16. APPENDIX J - SCHEDULE OF DRAINAGE PLAN REVISIONS

SCHEDULE OF MINOR CHANGES TO APPROVED SURFACE WATER DRAINAGE DRAWINGS

B

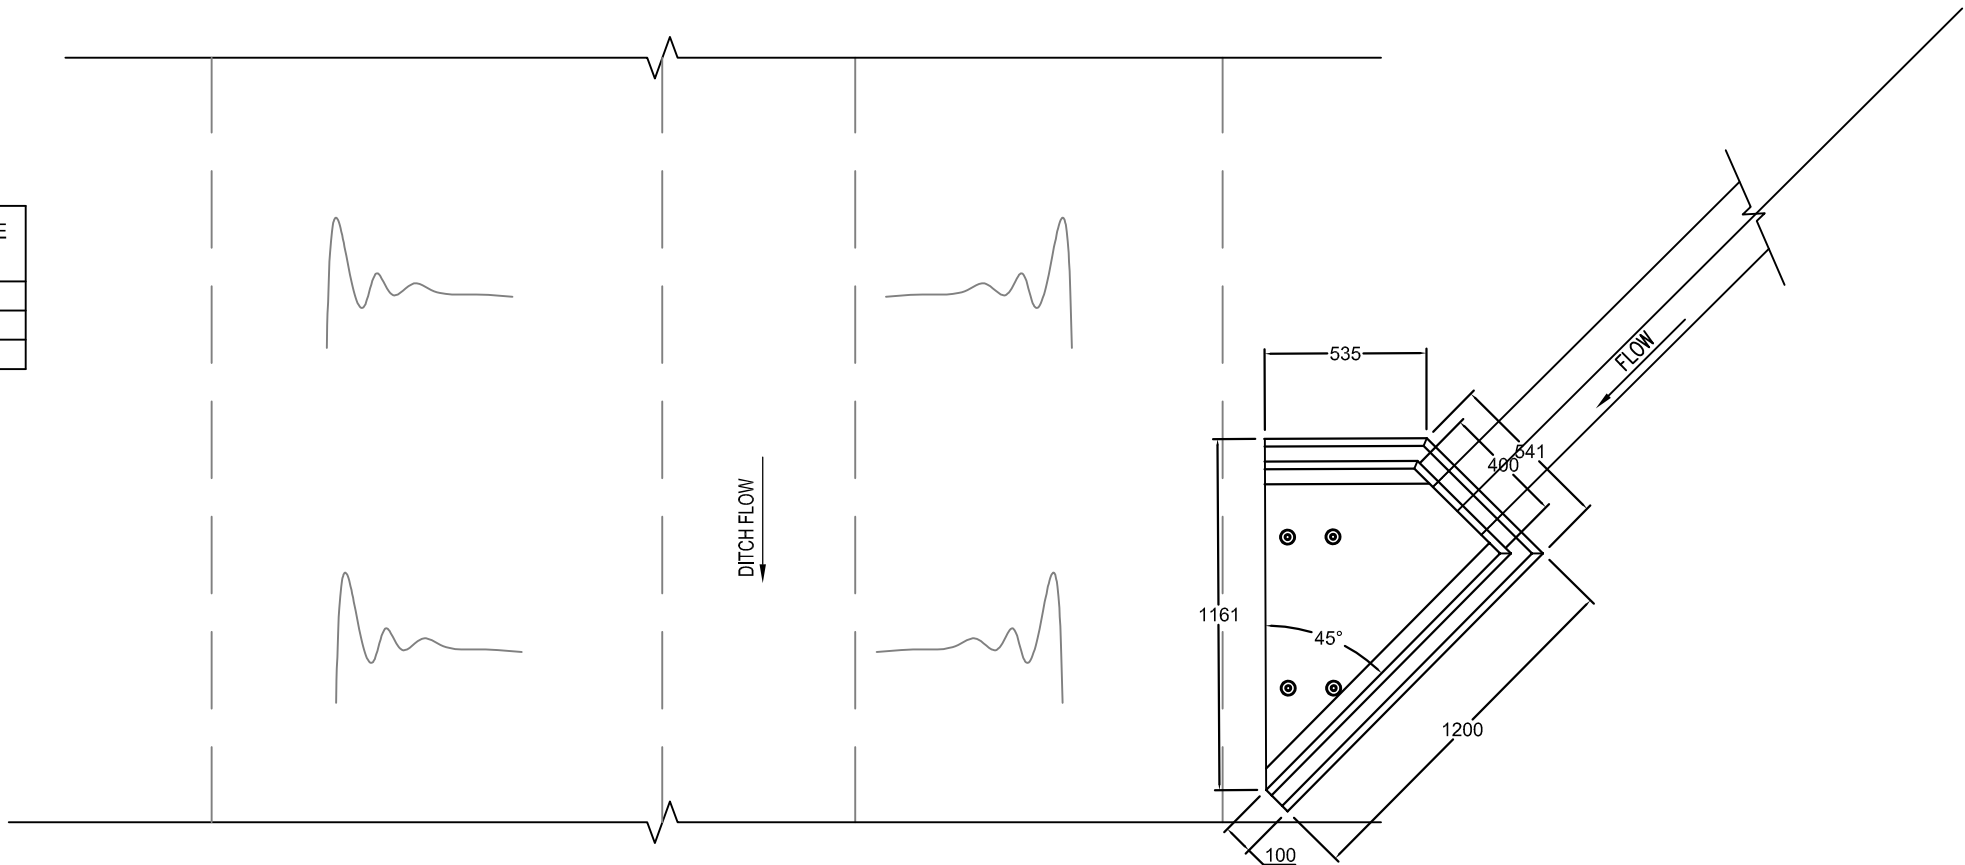
SAL-HYD-PH1-ZZ-DR-C-7110			
Rev P04	ARUN Approved Issue.		
Rev C01	Construction Issue *no changes*		
Rev C02	Headwalls updated.	Headwall changed to be more angular. At the request of ARUN	Detail angled to discharge with the flow direction.
Rev C03	H&S Issue - title block changed	title block changed	Error corrected
Rev C04	As built Issue - title block changed	title block changed	Changed back to As-built
SAL-HYD-00-ZZ-DR-C-7721			
Rev P01	ARUN Approved Issue. Approved under BE21/20/DOC on 11/6/20		
Rev P02	Updated to remove Unit 3 from site plan	Plan base changed to reflect removal of Unit 3 (outline) footprint from base plan	NMA approved to change bell mouth into Unit 3 and removal of detail from that outline site. All other plans revised to reflect this change at planning officer request.
SAL-HYD-PH1-ZZ-RP-C-0010			
Rev 06	ARUN Approved Issue.		
Rev 07	Information updated to remove unit 3 from plans	Plan base changed to reflect removal of Unit 3 (outline) footprint from base plan	NMA approved to change bell mouth into Unit 3 and removal of detail from that outline site. All other plans revised to reflect this change at planning officer request.

SAL-HYD-PH1-ZZ-DR-C-7010

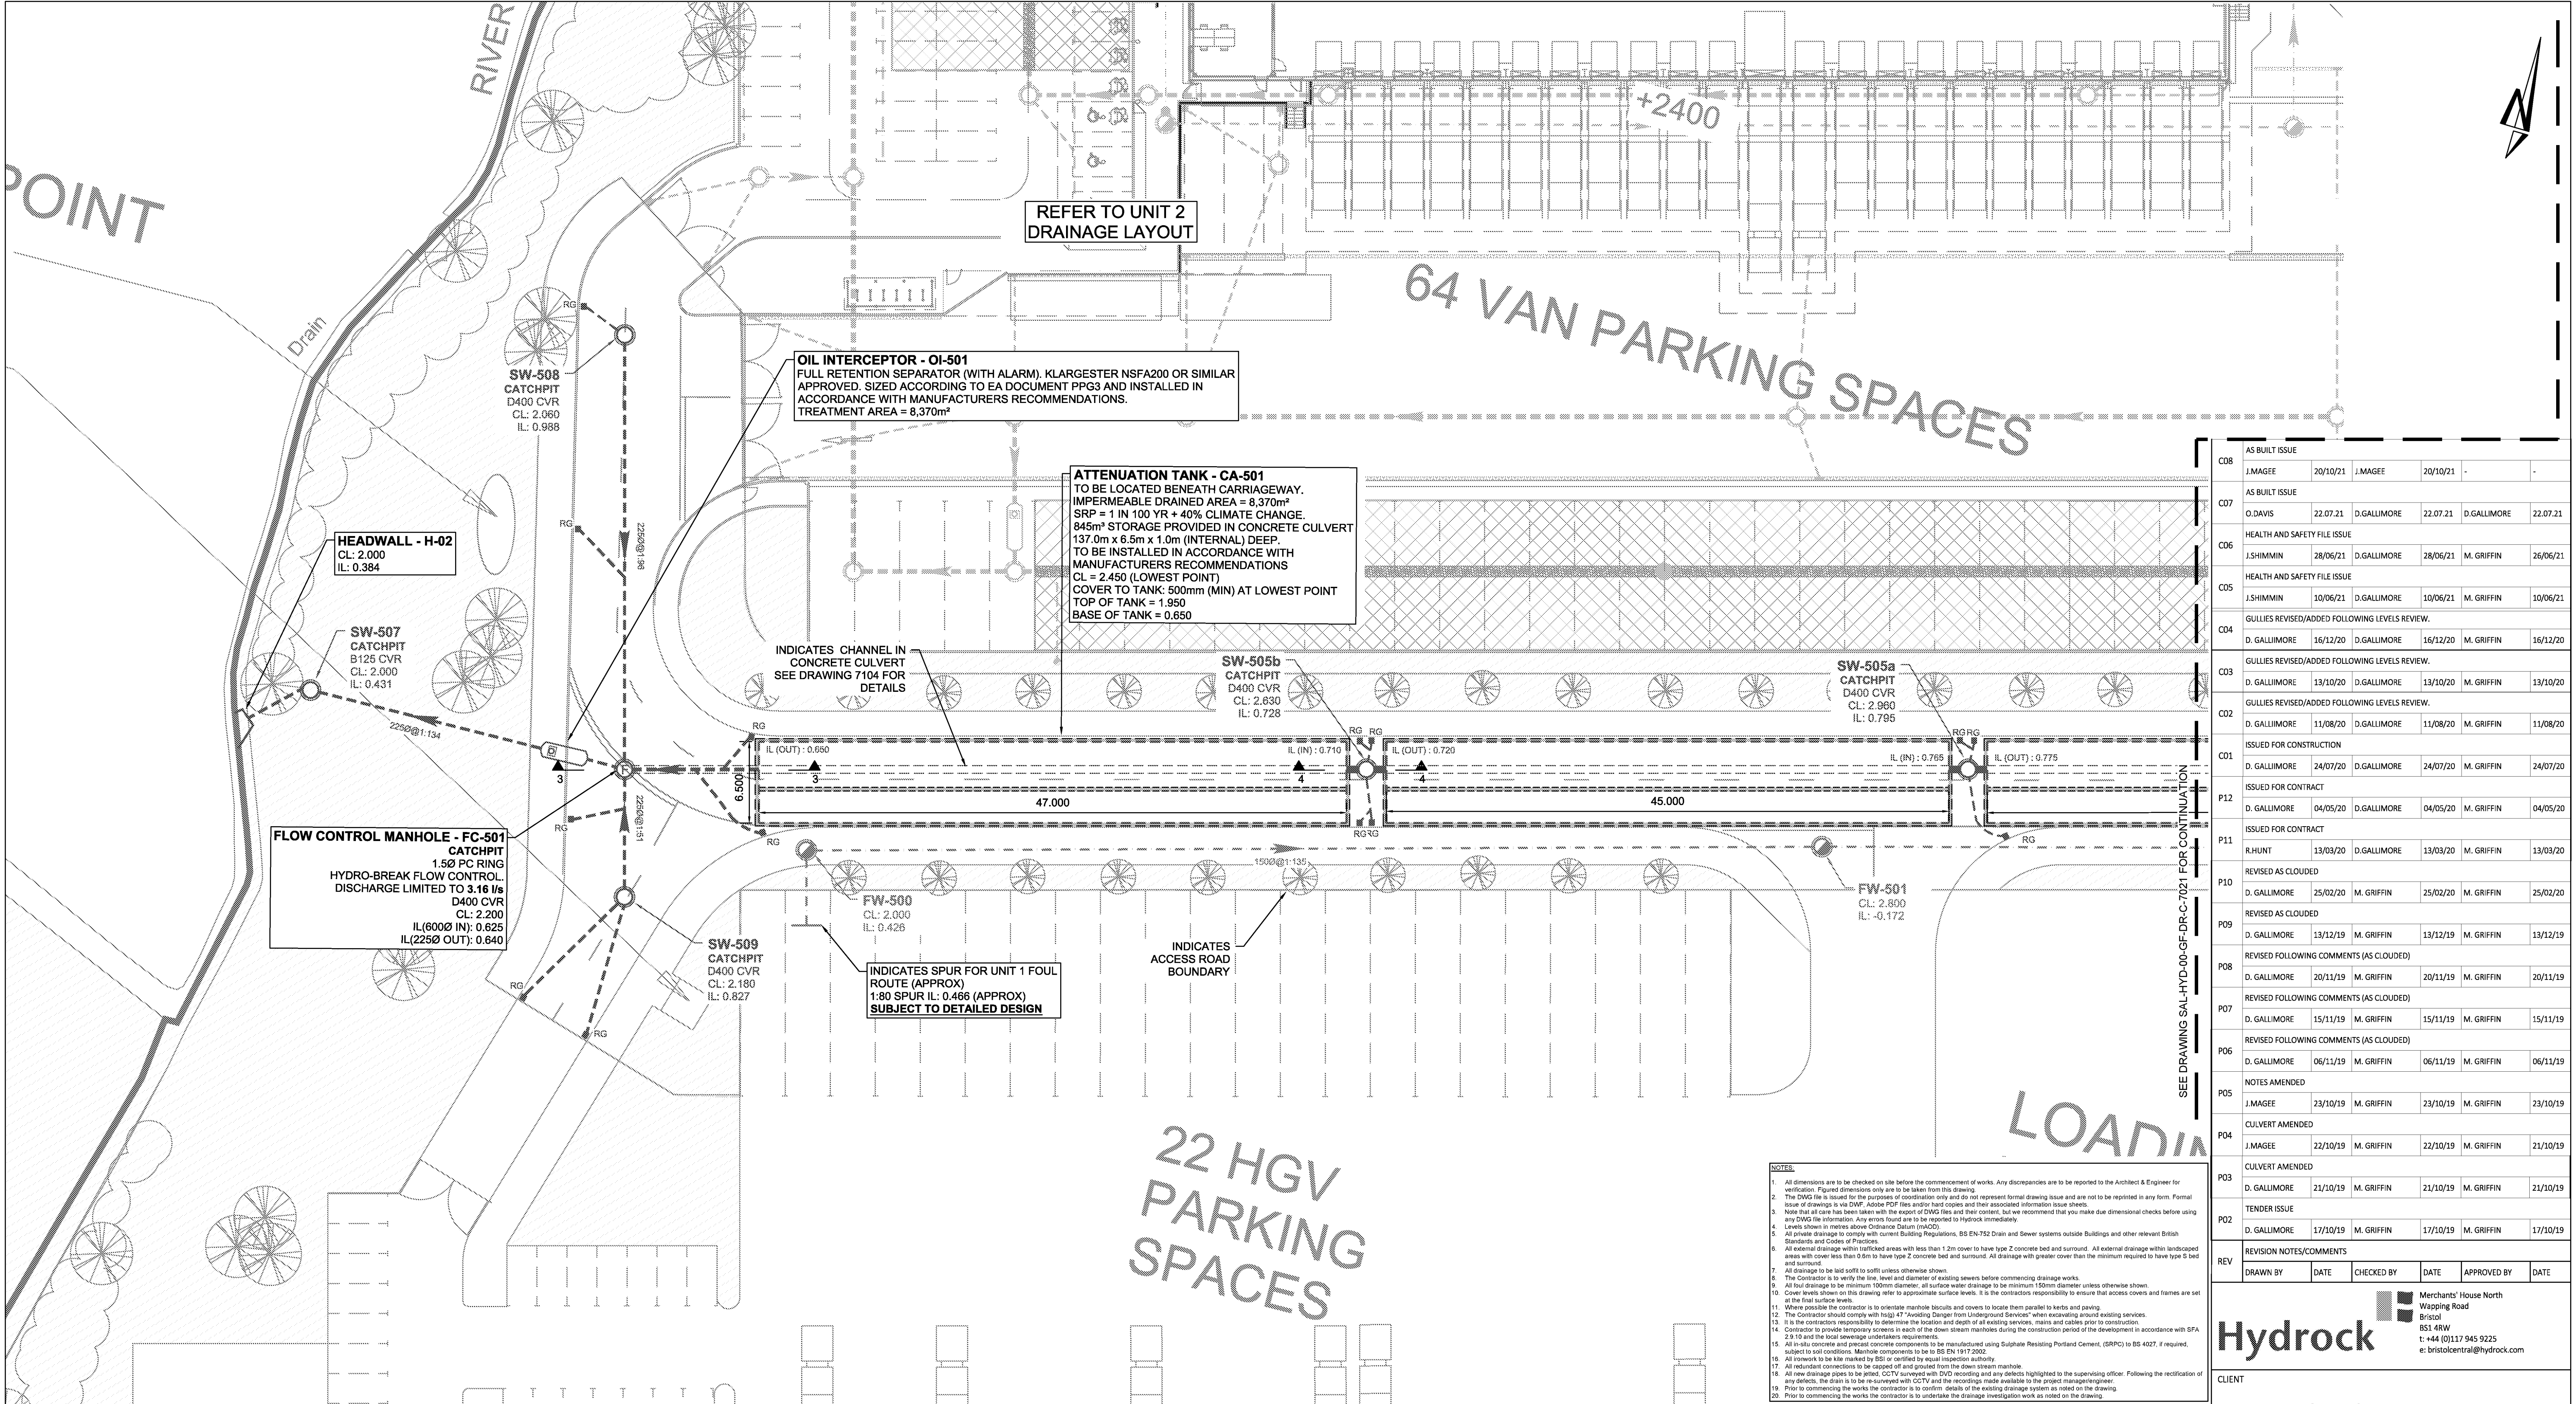
Plan number	Summary of revision	What has changed	Why it has changed
SAL-HYD-PH1-ZZ-DR-C-7010			
Rev P09	ARUN Approved Issue. Approved under BE21/20/DOC on 11/6/20		
Rev C01	Construction Issue *no changes*		
Rev C02	Canopy RWP's adjusted and courtyard Channel adjusted	Unit 2 rwp's updated to show internal down pipes (01) and front of building rwp's removed.	Following confirmation from architect to show detailed rwp positions.
Rev C03	MH 207 adjusted into soft & scissor lift gully added	MH 207 adjusted and gully added to scissor lift pit.	MH 207 originally shown in footpath but clashed with steps and moved into landscaping for better access. Gully added to scissor lift following comments from designer confirming need for gully
Rev C04	Courtyard Channel specs revised	Channel specs changed	Contractor wanted to change from ACO channels to Hauraton Recyfix channels.
Rev C05	Pump station arrangement updated following suppliers details issue	Pump station arrangements adjusted.	Drawing updated following details and specification received from supplier.

Rev C07	Typo amended *no changes*	Typographical error on plan	Error corrected
Rev C08	As built Issue *minor changes*	Levels and positions of drainage adjusted	As built survey provided by RG with locations updated to suit. As-built calcs were undertaken to update changes and all deviations from design levels confirmed acceptable and it will not adversely impact on the hydrological performance of the drainage system as a whole.
Rev C09	As built Issue *minor changes*	Levels changed to ADBLY July as-built mark up. Pipe Gradients adjusted accordingly. SW-211a added. SW-209 adjusted position.	The alterations were not picked up on previous as-built issue. Microdrainage calculations updated and show no adverse effects on the storm drainage network.
SAL-HYD-PH1-ZZ-DR-C-7011			
Rev P02	ARUN Approved Issue. Approved under BE21/20/DOC on 11/6/20		
Rev C01	Construction Issue *no changes*		
Rev C02	Offsite drainage revised to be shown as adopted	Foul drainage to change from private to public drainage	Main link from saltbox site to off site connection had to be shown as adopted so key and lines changed to suit for s104 application

Rev C03	Route of rising main adjusted following site requirements	Rising main route changed following site requirements and to avoid proposed bushes/trees currently shown where proposed rising main was to be placed.	Rising main changed to run directly across the main field north of the site to break manhole.
Rev C04:	Issued for construction *no changes*		
Rev C05	As built Issue *minor changes*	Levels and positions of drainage adjusted	As built survey provided by RG with locations updated to suit. As-built calcs were undertaken to update changes and all deviations from design levels confirmed acceptable and it will not adversely impact on the hydrological performance of the drainage system as a whole.
Rev C06	As built Issue *minor changes*	Levels changed to ADBLY July as-built mark up. Pipe Gradients adjusted accordingly. SW-211a added. SW-209 adjusted position.	The alterations were not picked up on previous as-built issue. Microdrainage calculations updated and show no adverse effects on the storm drainage network.
